**REPRESENTATIONS OF THE HISTORIC BUILDINGS AND MONUMENTS  
COMMISSION FOR ENGLAND (HISTORIC ENGLAND)**

**DEVELOPMENT CONSENT FOR THE BRAMFORD TO TWINSTEAD  
REINFORCEMENT**

**APPLICATION REF: EN020002**

## Written Representation: Historic England

b) Hintlesham Hall and Hintlesham Woods

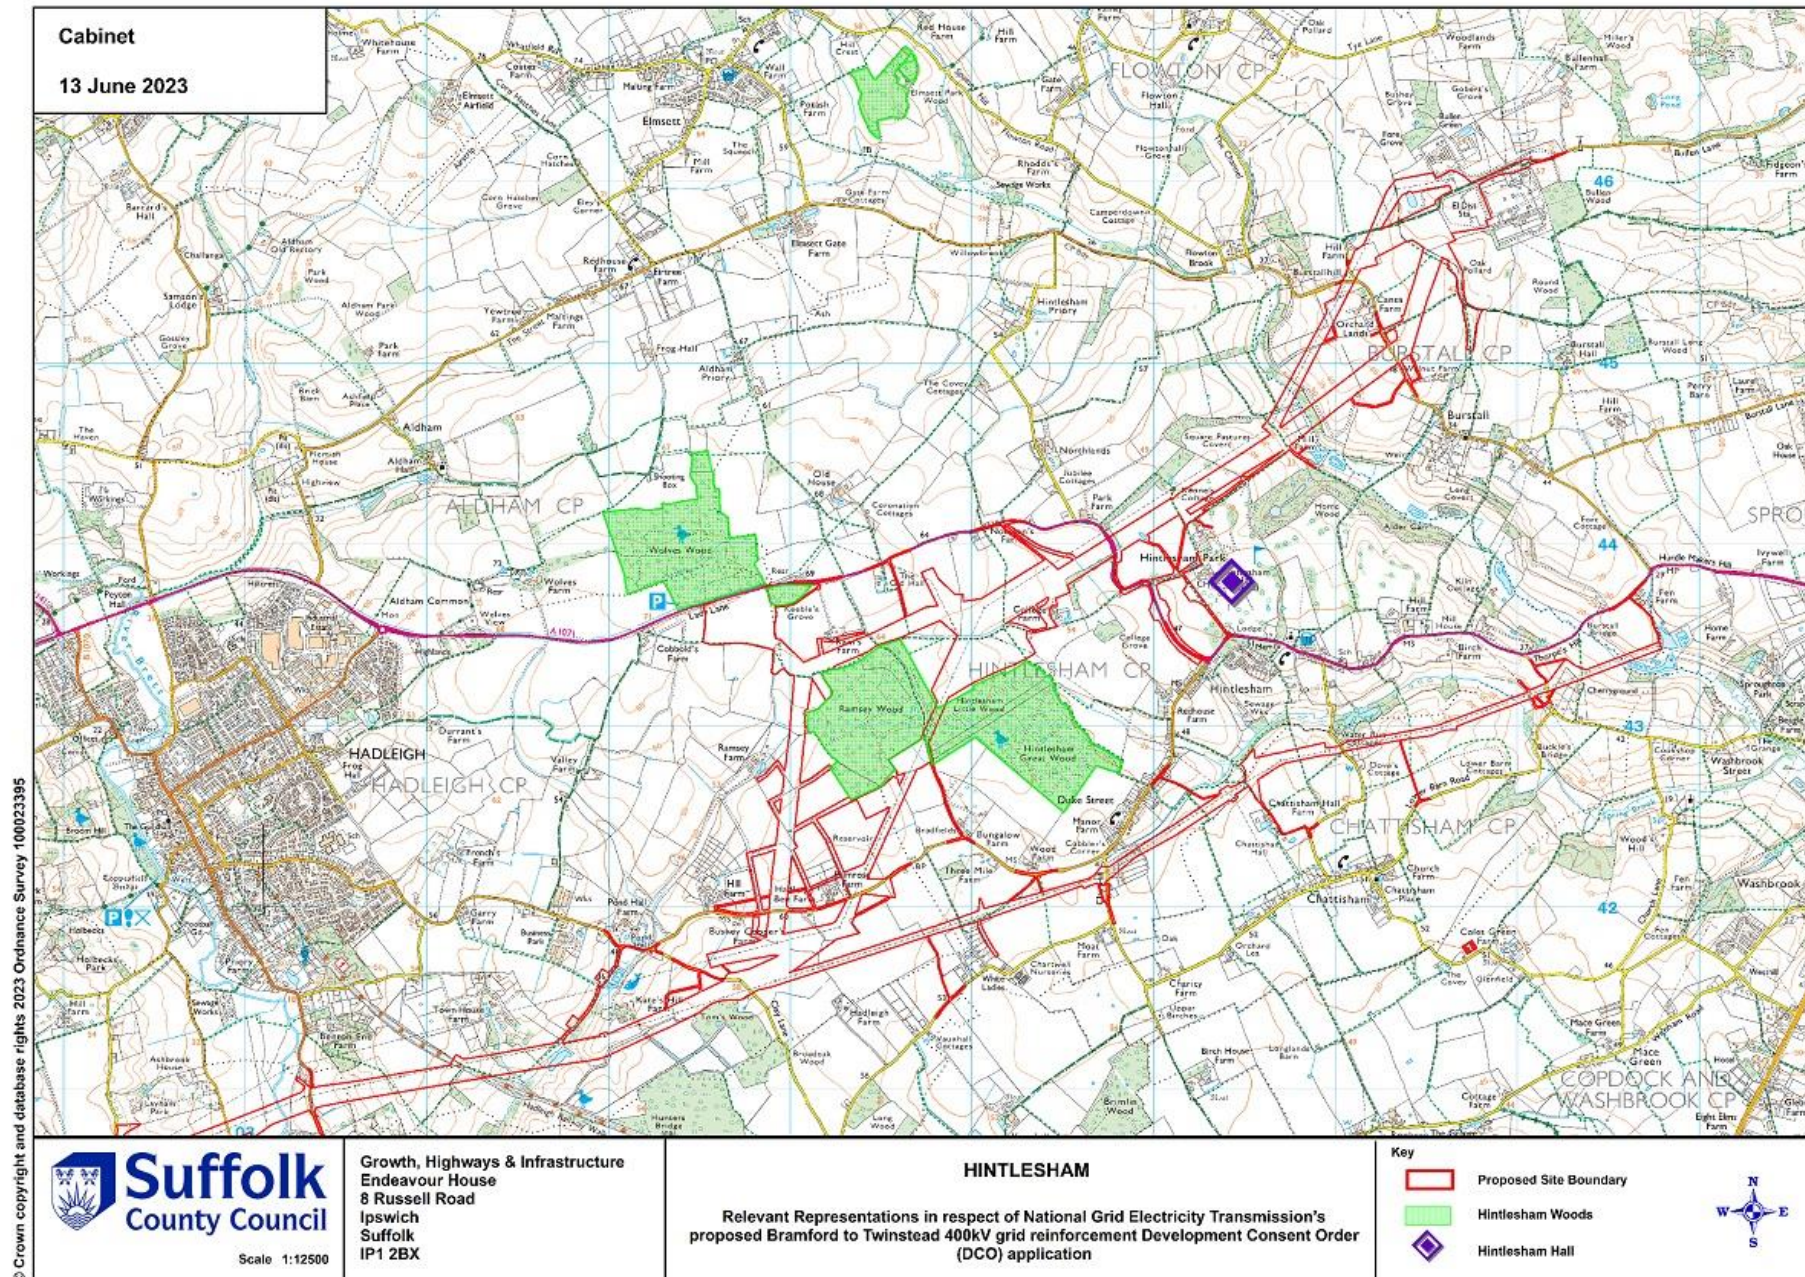
- 2.11 We do not think the limits of deviation and potential changes to the positions of pylons RB3 and RB4 have been fully taken into account.

- 3.1.1 We have raised several concerns regarding the limits of deviation (article 5) around Hintlesham Hall. Historic England has spent considerable time with the applicant considering the location of pylons RB3 and RB4 in this location to prevent unnecessary harm to the highly graded listed building.
- 3.1.2 Building to the extent of the proposed limits of deviation would increase the pylon's prominence and impact on the setting of Hintlesham Hall.

- 3.3.1 We broadly accept the findings of ES Appendix 8.2 – Annex A Hintlesham Hall Assessment. Except the assessment of the impact on Hintlesham Hall and its consideration of the line of deviation. We do not think the limits of deviation and potential changes to the positions of pylons RB3 and RB4 have been fully taken into account.

- 3.3.3 The document concludes the effect would amount to no more than minor adverse. We consider the impact would be adverse if the proposed pylon RB3 was moved southwest on the line or RB4 was moved northeast on the line. We agree with the conclusion of the report "that the degree of change to the historic assets would not result in substantial harm to Hintlesham Hall or its ancillary buildings".

- 3.3.4 We recommend the assessment of the setting of, and impact of the proposed development on, taking into account the potential locations of the pylons RB3 and RB4 is reconsidered by the applicant and, where appropriate, the document revised and reissued for examination.

- 3.3.5 We would recommend that proposals should provide a more definite location for the pylons further limiting their relocation.
